SUBJECT: **Response to On-hold Letter for Section 401 Water Quality Certification and Jordan Lake Watershed Riparian Buffer Authorization Application** for the replacement of Bridge No. 161 over North Prong Stinking Quarter Creek on SR 1124 (Stafford Mill Road), Alamance County, North Carolina. Federal Aid Project No. BRZ – 1124 (5), TIP No. B-4401.

REFERENCE: Application for Section 401 Water Quality Certification and Jordan Lake Watershed Riparian Buffer Authorization and Notice of Intent to Use Section 404 Nationwide Permits 3 and 13, dated February 20, 2013.

Buffer Drawing  
 Sheet 3 of 5  
 Revised 4/8/2013

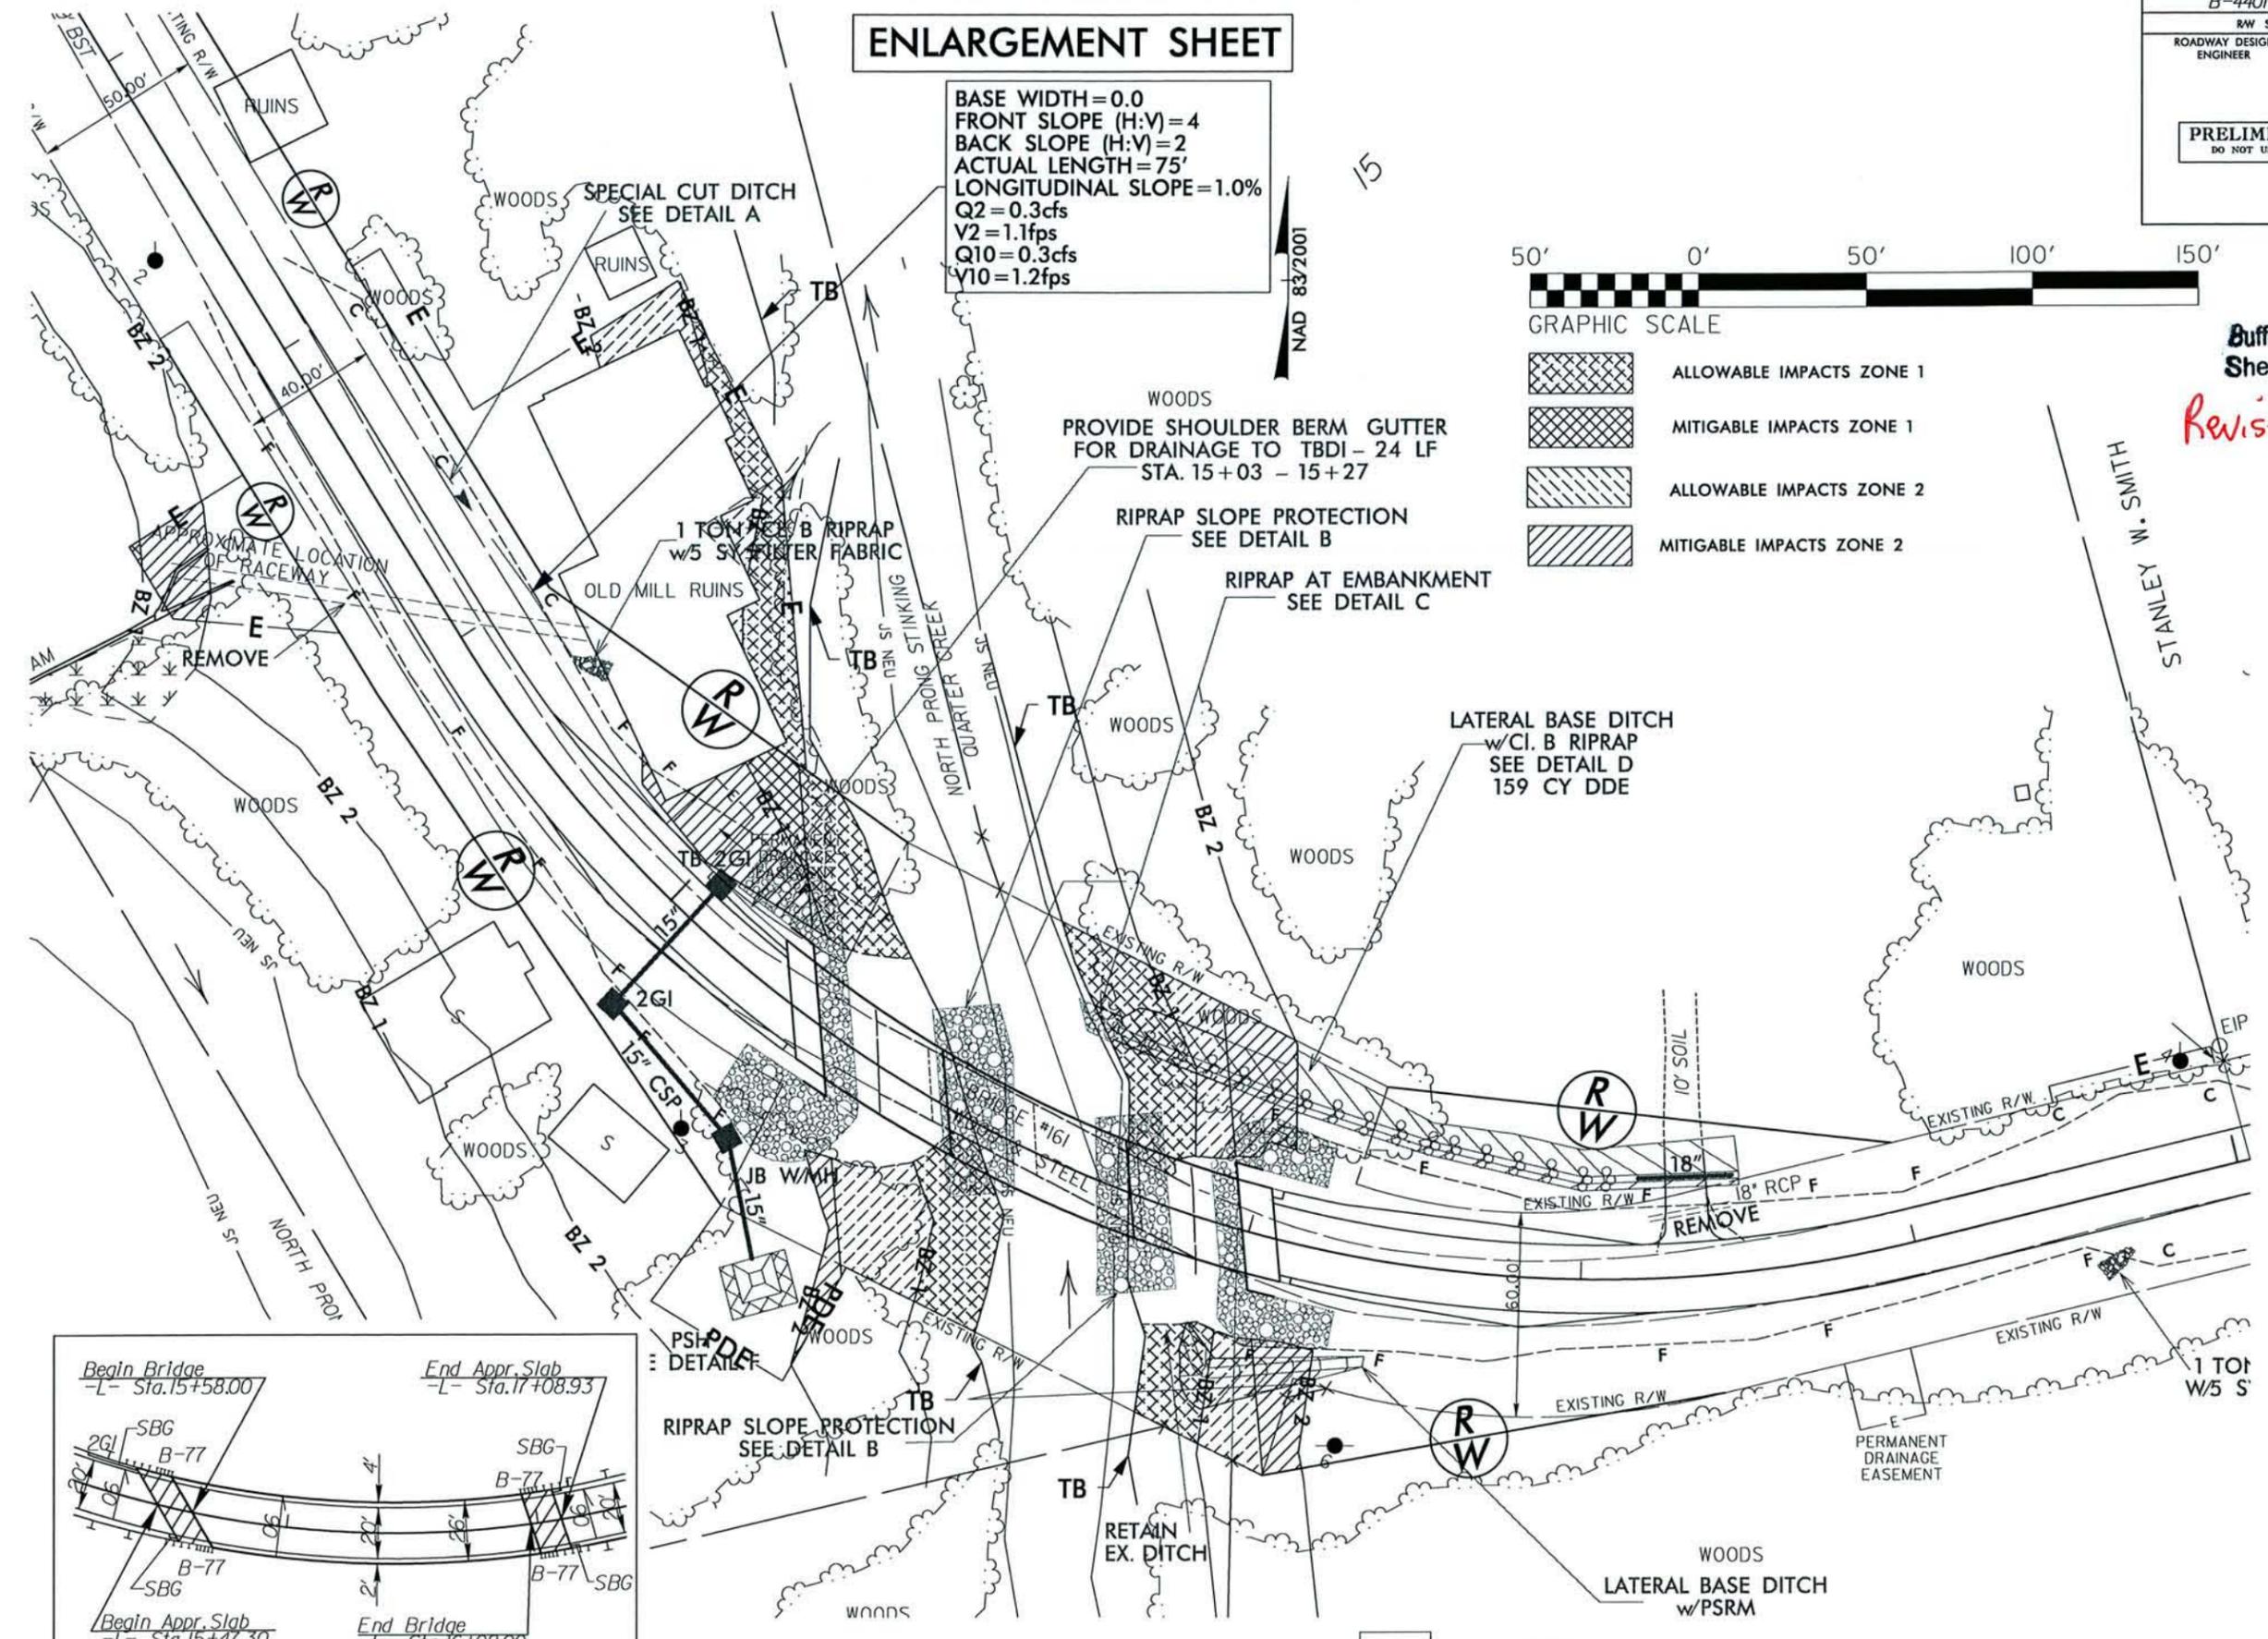
- The buffer drawings were revised because, after review, it was determined that the buffer impacts resulting from two lateral base ditches should have been considered “Mitigable” along their entire length; however, the portions of the ditches that ran through the “Bridge” buffer impact zone were considered “Allowable” in our original permit application. The hatching for these impacts has been updated on the buffer drawings to reflect this change and the buffer impacts have been updated on the buffer impact summary sheet and in the Pre-Construction Notification (PCN).
